25TH Nov 2015

Submission of objection to the Albion Park Rail bypass by Don Grey to the RMS to NSW
Department of Planning and Environment.

# Map 3 - Southern Interchange

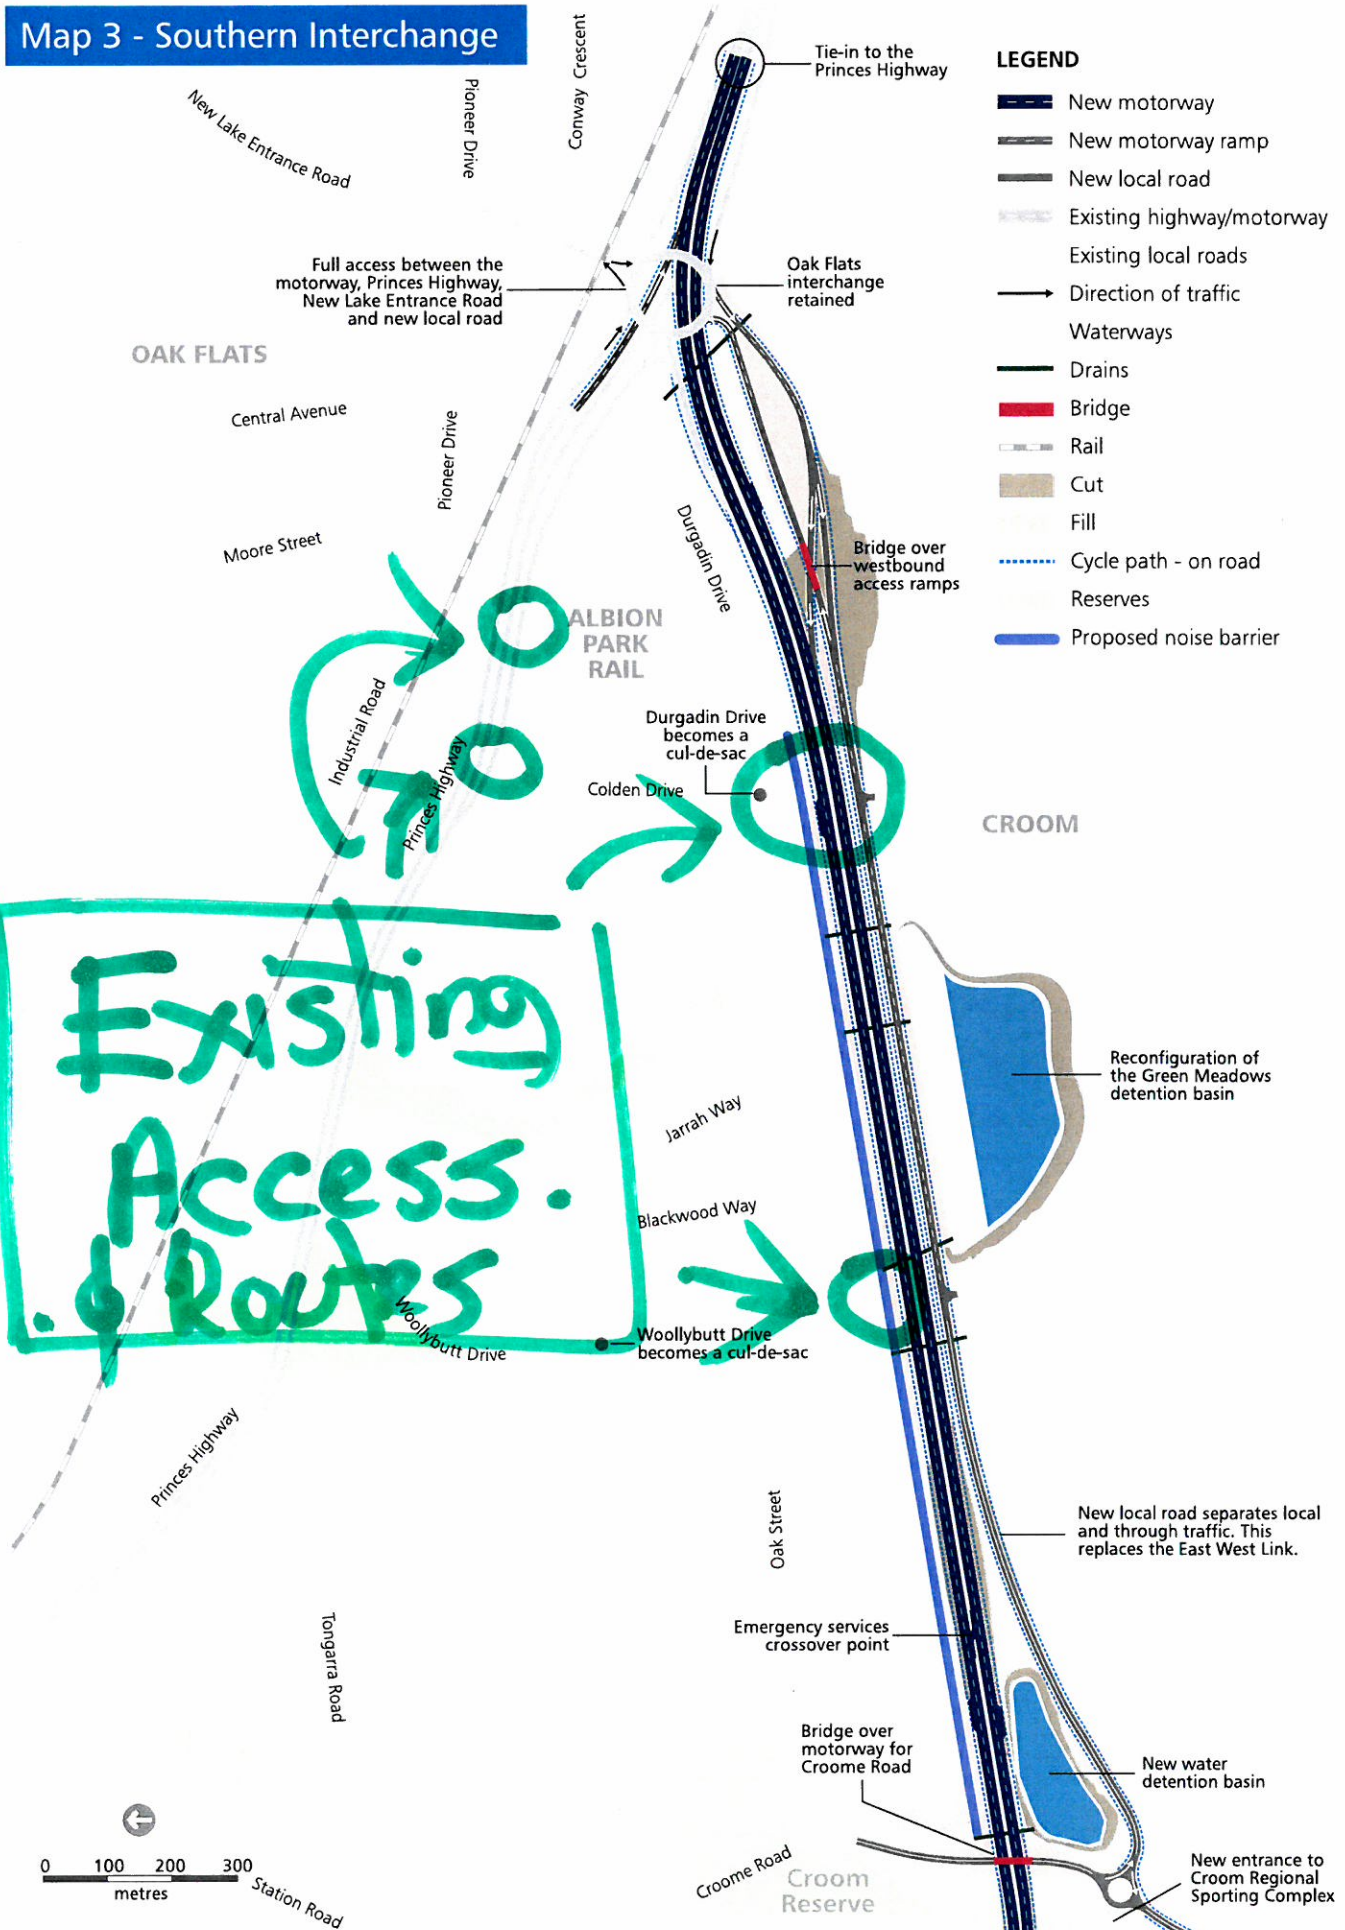
The most feasible option for the RMS is to redesign the western alignment and move it further east to take less grazing land off Meadow View.

The proposal for the on/off ramps must be redesigned and moved south away from the Albion Park Airport east/west runway for safety of aeroplanes.

Moving the design for the southern off ramp further south will mean taking less productive dairy farm land.
